TOWN AND COUNTRY PLANNING ACT 1990 FULL

Reference:	H16-1111-22	Date of Decision:	5th January 2023
Applicant:	Mrs F T Mir Javadi 13a Fishpond Lane Holbeach Spalding PE12 7DE		
Location:	106 Halmer Gate Spalding		
Description:	Change of use from residential dwelling to HMO

HMO AT 106 VALMER GATE
SPALDING FOR
MRS F + MR JAVADI

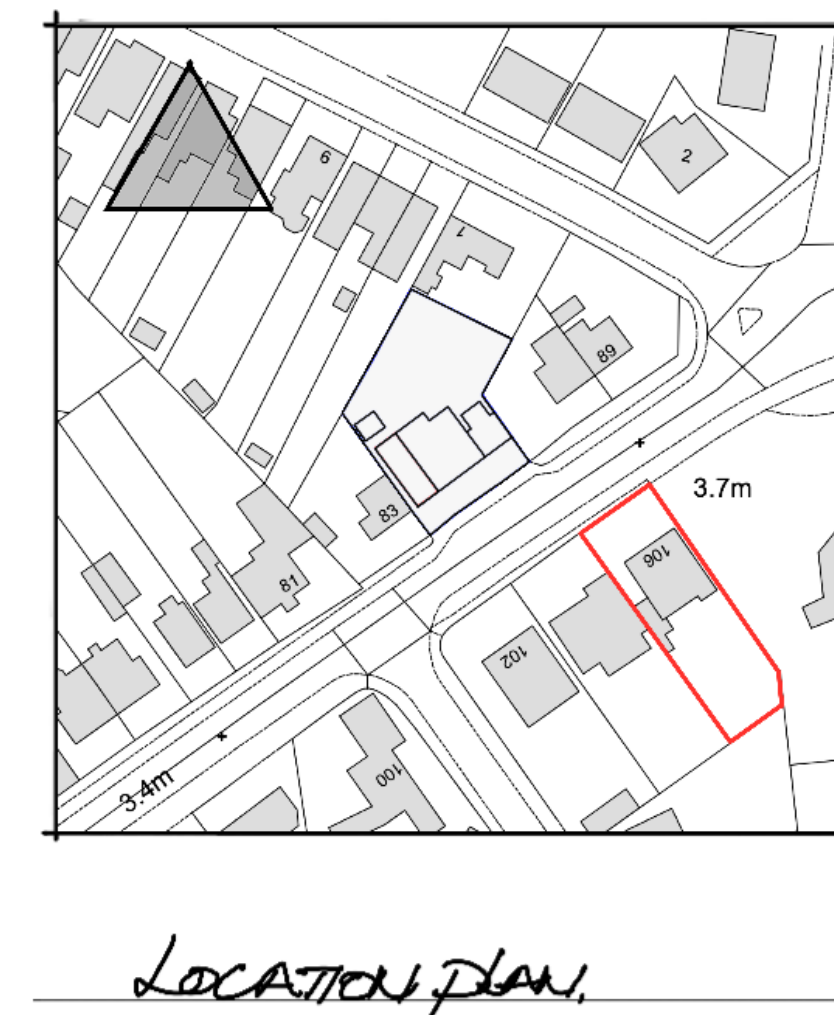
- 1 The property is considered to be of an inadequate size to accommodate what would likely be a minimum of 9 persons by virtue of small bedroom sizes (2 bedrooms on first floor) in the context of the Nationally Described Space Standards (2015) (NDSS), and only a single kitchen and dining space. This would represent an over intensification of the use of the property and may adversely impact the well-being of occupants or lead to outside gathering with a consequent amenity impact on neighbouring occupants. Overall, the noise and disturbance that would be generated would be uncharacteristic for an area of modest housing in single family occupancy.

- 2 Given that the HMO is intended to accommodate a minimum of 9 persons, there is the potential for a large number of vehicles to be associated with the property. The application

site is only capable of accommodating 3 off-street parking spaces for vehicles and the property only has a small road frontage. The proposal would likely result in the indiscriminate parking of vehicles on Halmer Gate and would impede traffic flow along a road that is particularly busy during school arriving and leaving times, thus being an inconvenient arrangement.
